# CITY OF ALBUQUERQUE

**Re: Campbell Brewery  
4814 Hardware NE  
30-Day Temporary Certificate of Occupancy- Transportation Development  
Transportation Development Final Inspection  
Architect's Stamp dated 08-07-15 (F17-D097)  
Certification dated 02-01-18**

SITE PLAN

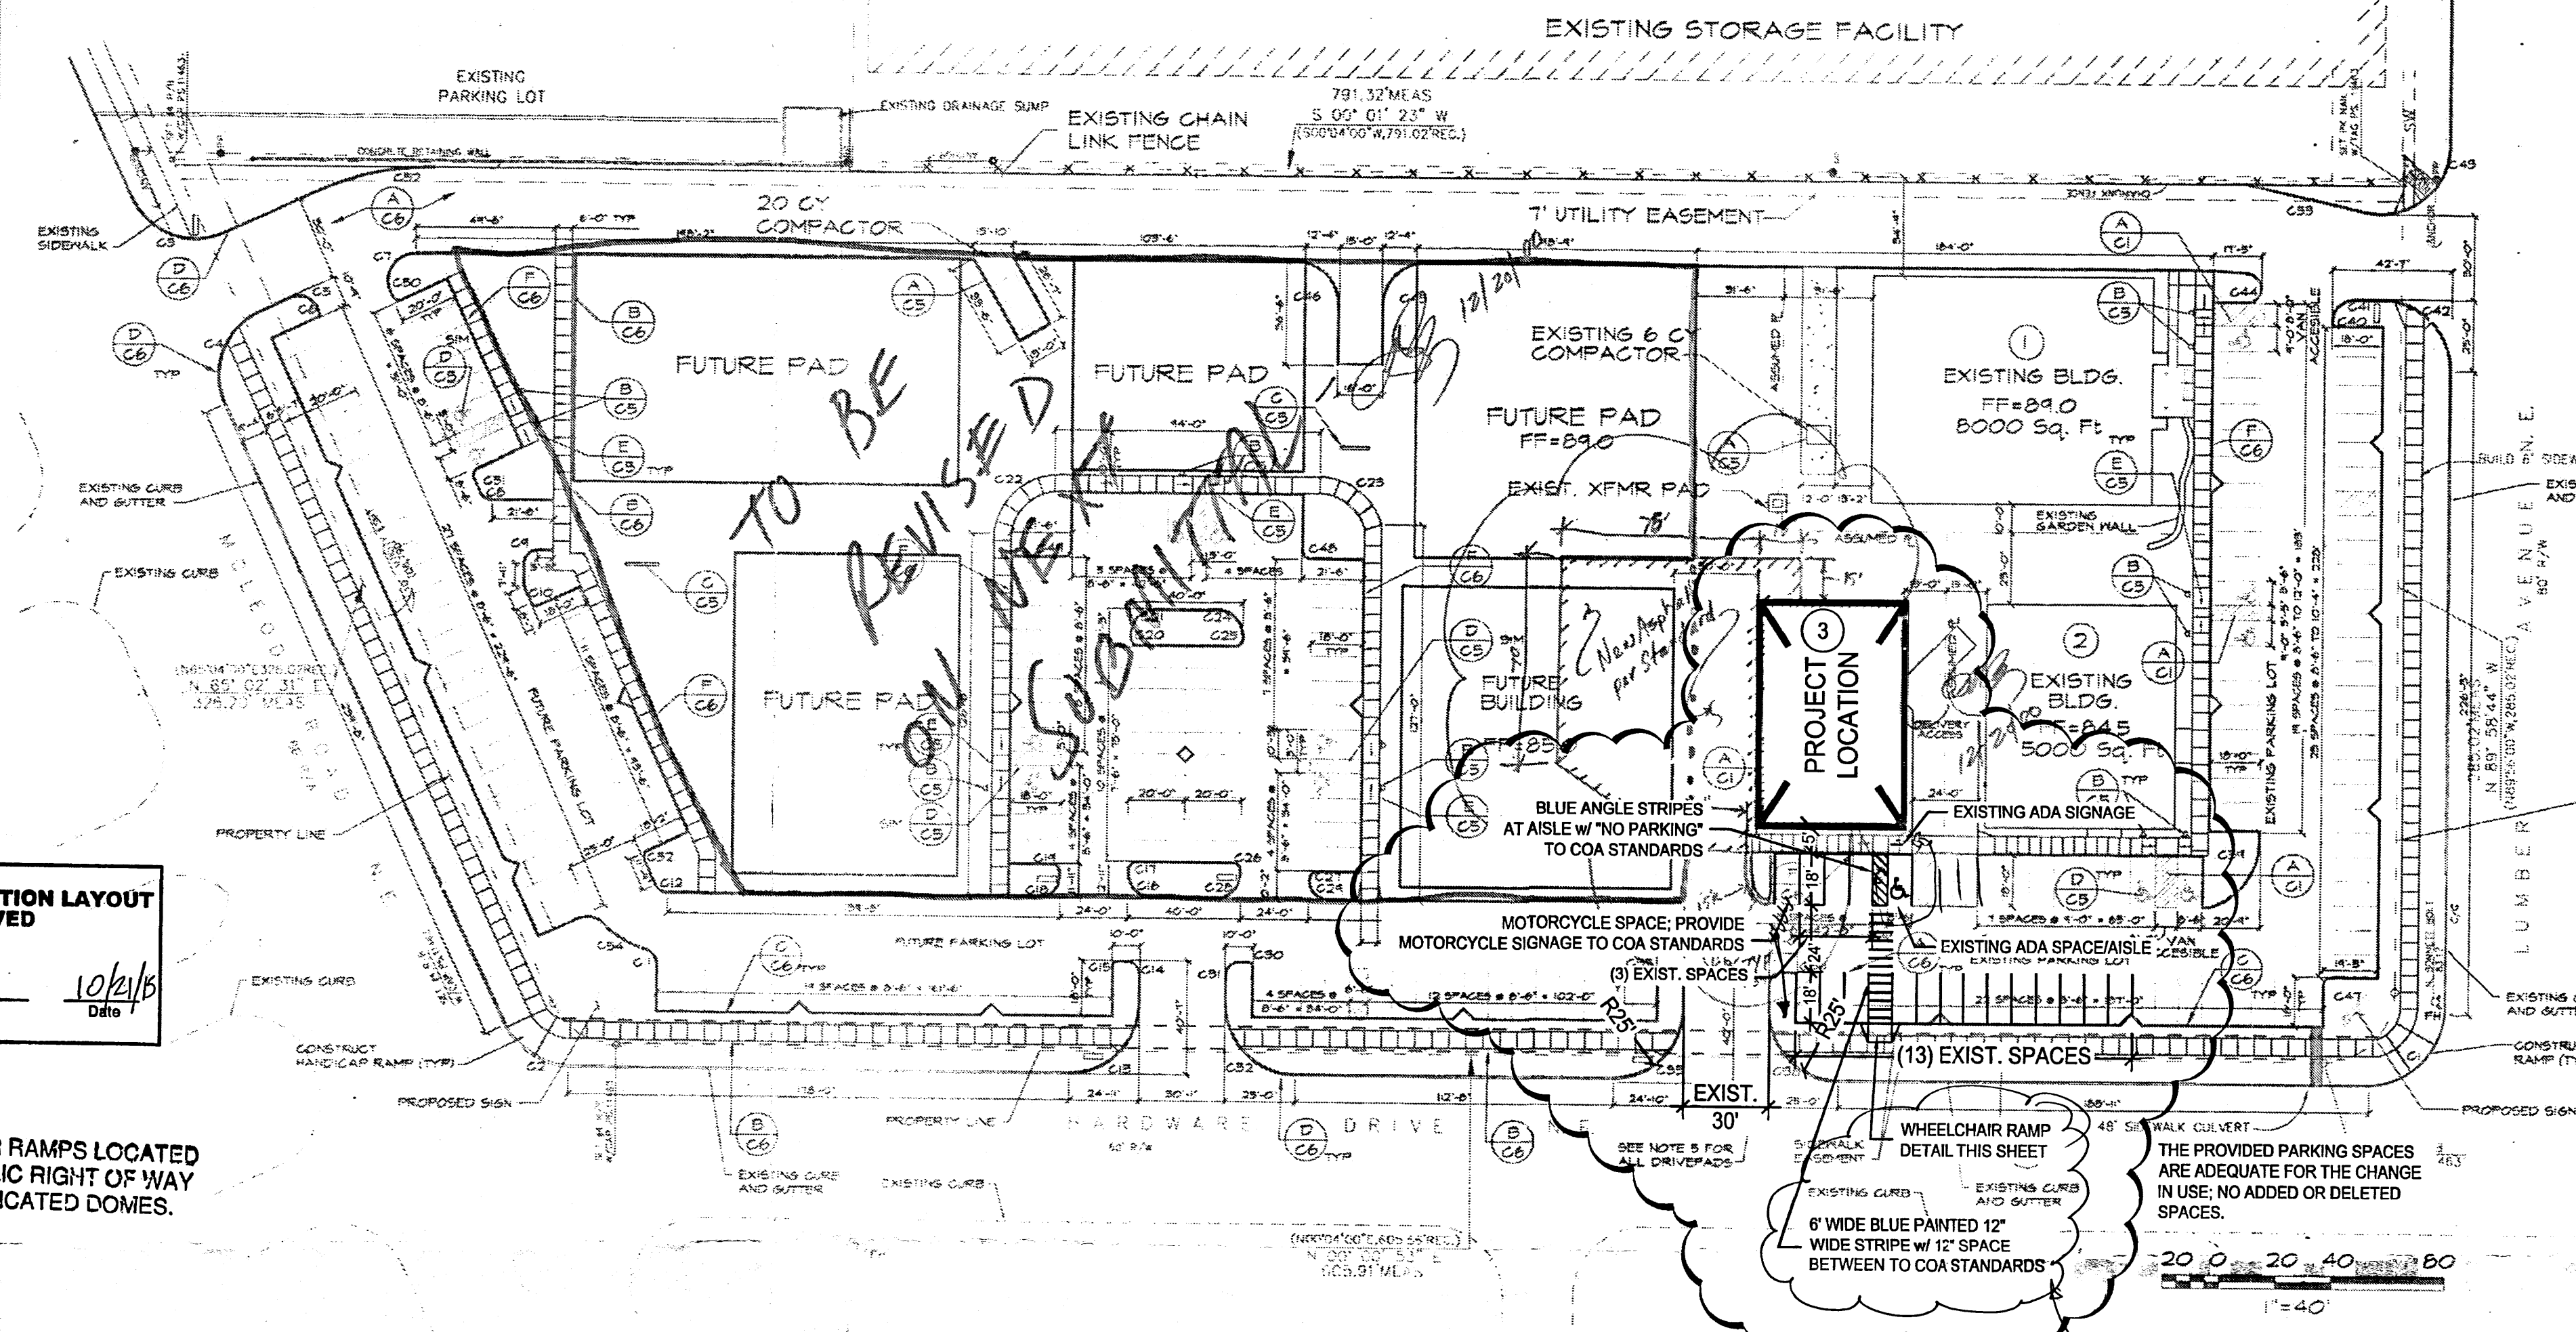
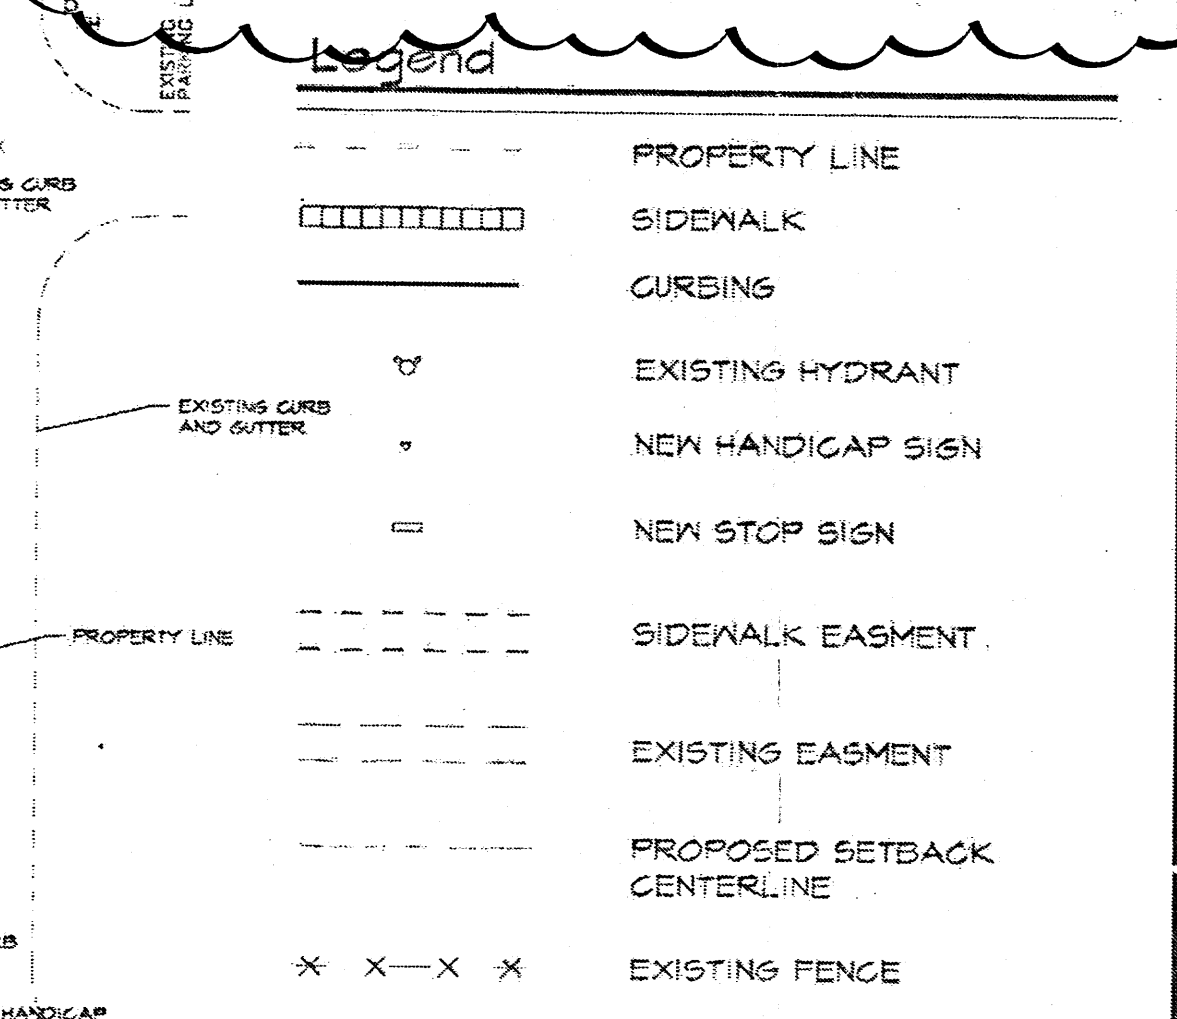
1. The ADA accessible parking sign must have the required language per 66-7-352.4C NMSA 1978 **"Violators Are Subject to a Fine and/or Towing."**
2. The handicap accessible spaces must include an access aisle. Van accessible aisles should be 8ft wide; all others should be 5ft wide.
3. Please provide an ADA ramps to allow a connection to building entrance from the ADA access aisle.
4. The ADA access aisles shall have the words **"NO PARKING"** in capital letters, each of which shall be at least one foot high and at least two inches wide, placed at the rear of the parking space so as to be close to where an adjacent vehicle's rear tire would be placed. (66-1-4.1.B NMSA 1978)
